Your ref: 3/2025/0133

Date: 22 April 2025

Location: Loft Shay Farm Clitheroe Road Ribchester PR3 2YQ
Proposal: Change of use of land to form extended residential curtilage. Proposed detached garage to include solar panels and living accommodation above. Insertion of second floor side facing windows to main dwelling.
Grid Ref: 364067 438228

SHEET:
Proposed Plans

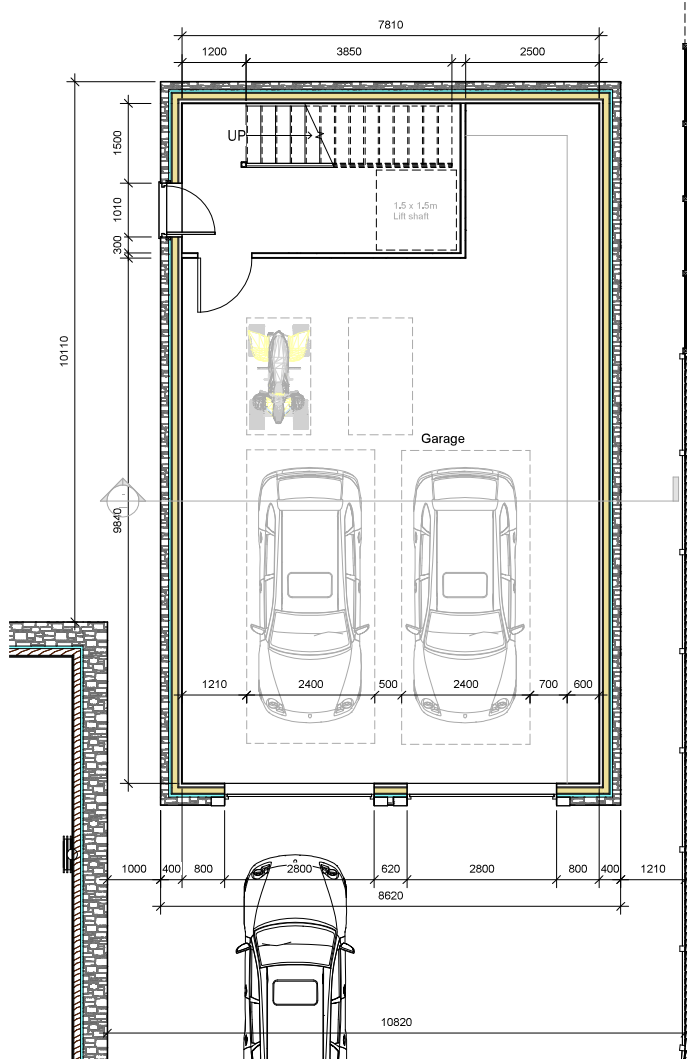
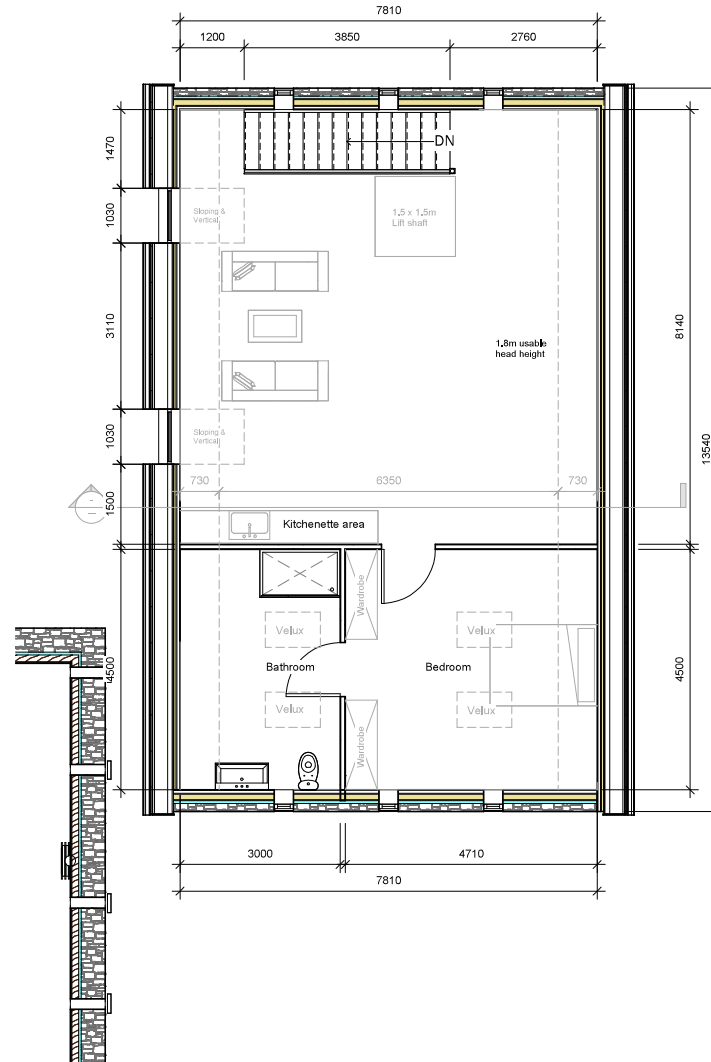
The recommended minimum internal dimensions for a single garage size is 6m in length and 3m wide. The recommended distance of 6m is based on the length of a large family

car (Ford Mondeo Estate 4.58m long), clearance at the rear of the car (200mm), overhang of the garage door (600mm) and room to stand in front of the car and open/close the garage door (600mm). The LHA has reviewed the proposed floor plans, drawing A2.2.1 and note that the garage have been designed to an acceptable internal size to provide parking.
